Response to Submissions | New Residential Community 2 and 2A Bullecourt Avenue (SSD- 97092958)

This Submissions Report has been prepared by Beam Planning on behalf of Mirvac Residential (NSW) Developments Pty Ltd (the Applicant) in relation to the State Significant Development Application (SSDA) (SSD-97092958) for a new residential community located at 2 and 2A Bullecourt Avenue, Milperra (the site).

TREE REMOVAL SUMMARY

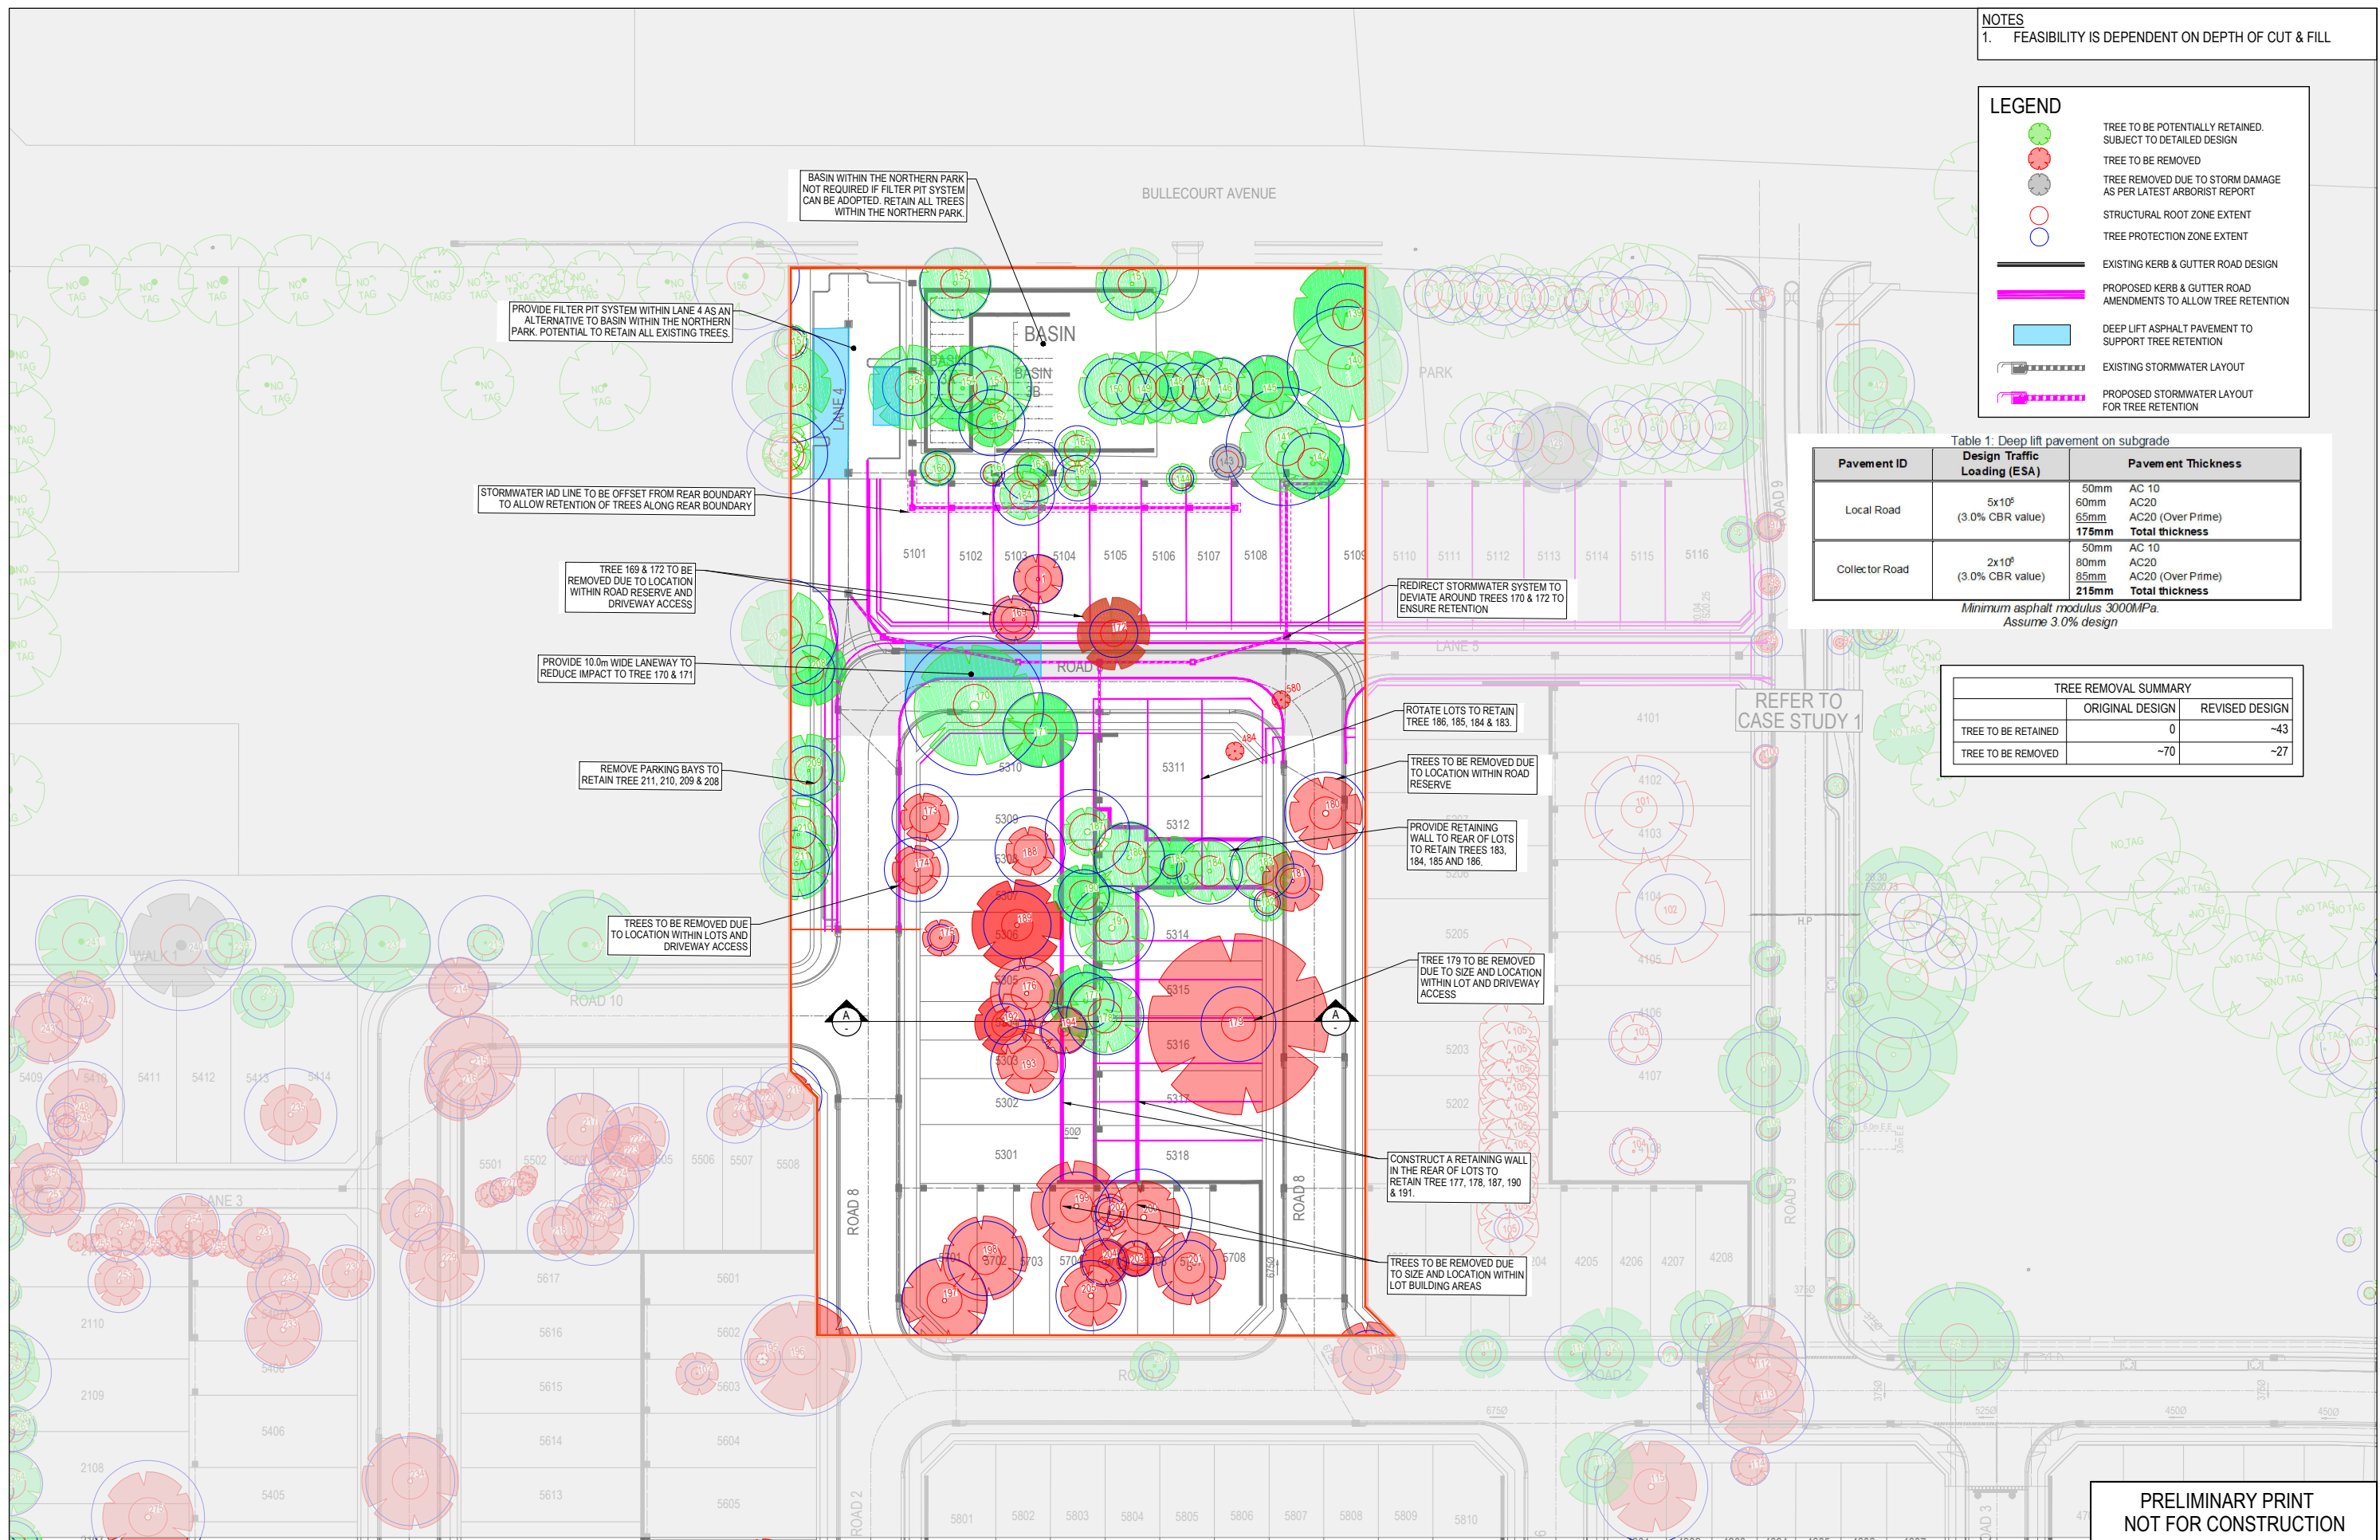
Council also noted that CPW should be retained across the entire subdivision. Additionally, Council further stated that "no genuine attempt has been made to retain vegetation within the proposed subdivision".

Notwithstanding, since the issue of the RFI, further opportunities have been found to retain additional CPW across the residential zoned land within the site. An amended design has been prepared which identifies the retention of Trees 56, 217, 400, 401, 403 and 408 (refer to civil plans at **Appendix B**). This has been achieved by implementing a kerb blister on Road 2B and amalgamating lots under the future SSDA 2, resulting in a reduction of 3 future residential lots.

The trees proposed to be retained in the amended design are located outside of areas requiring remediation and are capable of being accommodated via changes to the proposed bulk earthworks. Importantly, as shown in the Arboricultural Impact Summary at **Appendix W**, the trees proposed to be retained are of the highest Arboricultural value, which were all assessed as having a long useful life expectancy and high retention value.
